July 6, 2023

SUBJECT SE-23-00014 – SEPA Checklist Response to Comments
Summit Deli & Chevron
521 State Route 906
Snoqualmie Pass, Washington 98068

At the request of Bob Shin, Aerotech Environmental Consulting, Inc. (“Aerotech”) has prepared the following response to comments regarding SEPA Application SE-23-00014. The Kittitas County Community Development Services (“KCCDS”) transmitted comments on June 20, 2023.

Figure 2 Proposed Excavation Extents

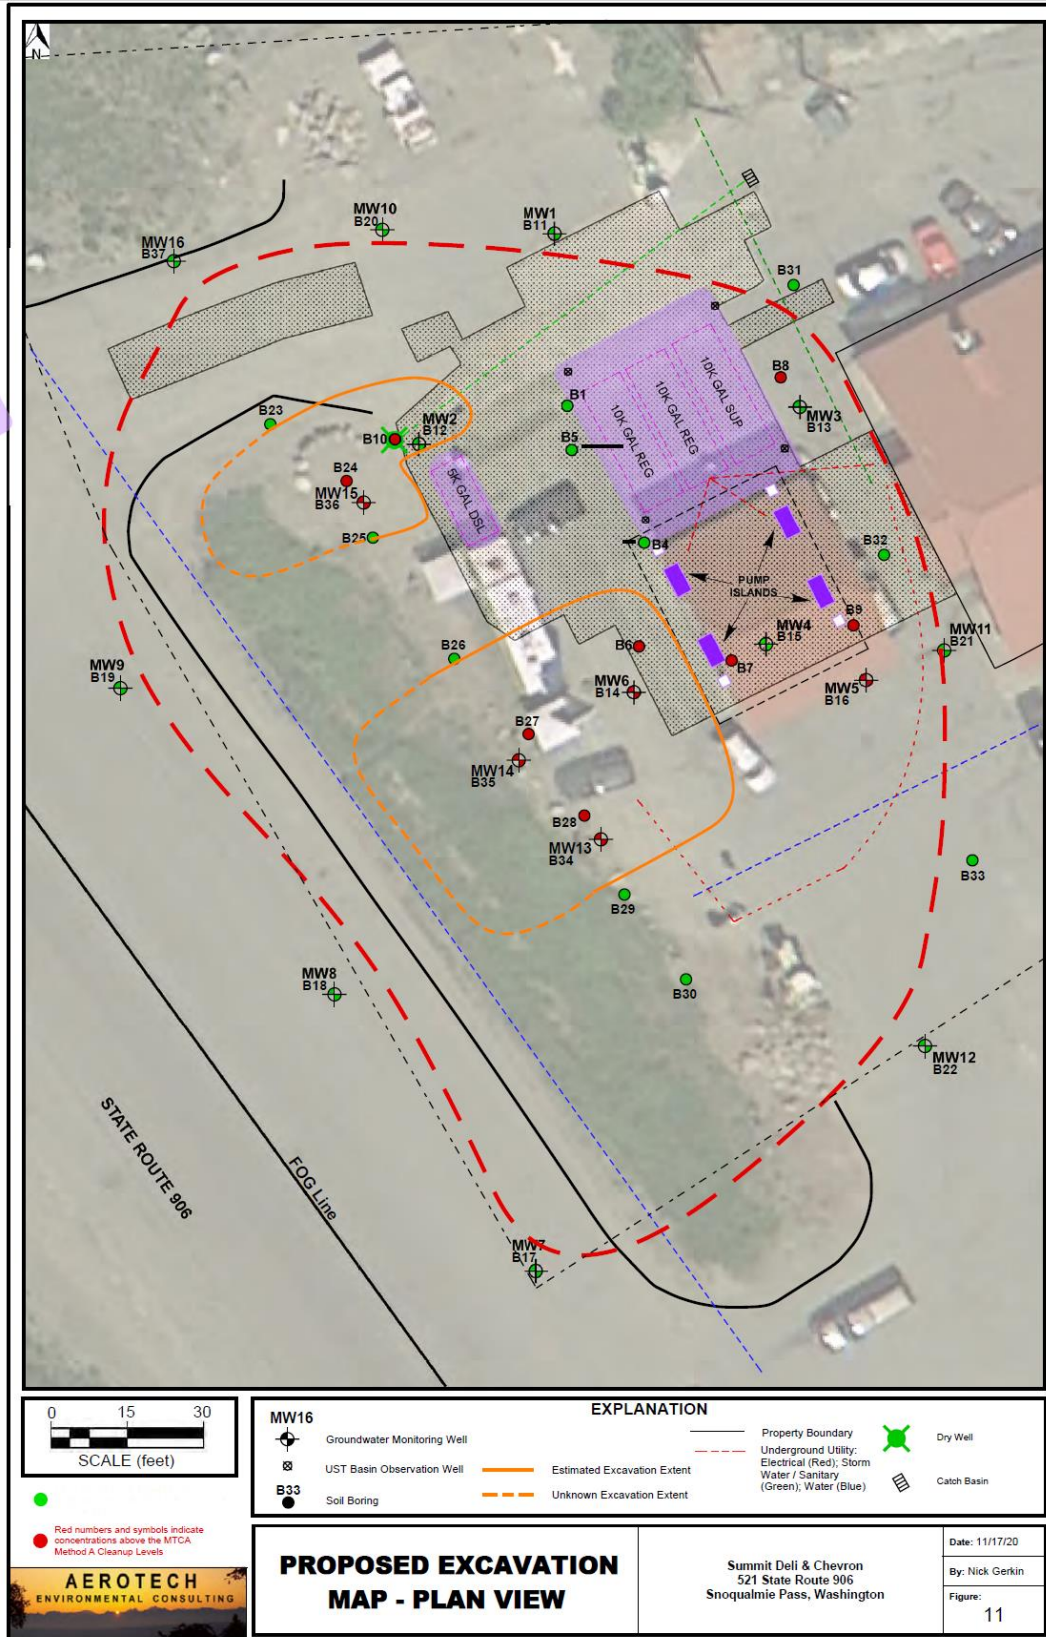
The applicant must consider how the Petroleum Contaminated Soil (PCS) will be managed. PCS should not be used as clean fill and needs to be treated prior to any use.

The management of PCS will be completed according to the established state and local requirements, as well as the disposal facility to be utilized. Any backfill reused will be verified via an onsite analytical laboratory to ensure no PCS is used as clean overburden. Sampling of stockpiles will occur according to Table 6.9 taken from the Guidance for Remediation of Petroleum Contaminated Sites, Ecology Publication No. 10-09-057.
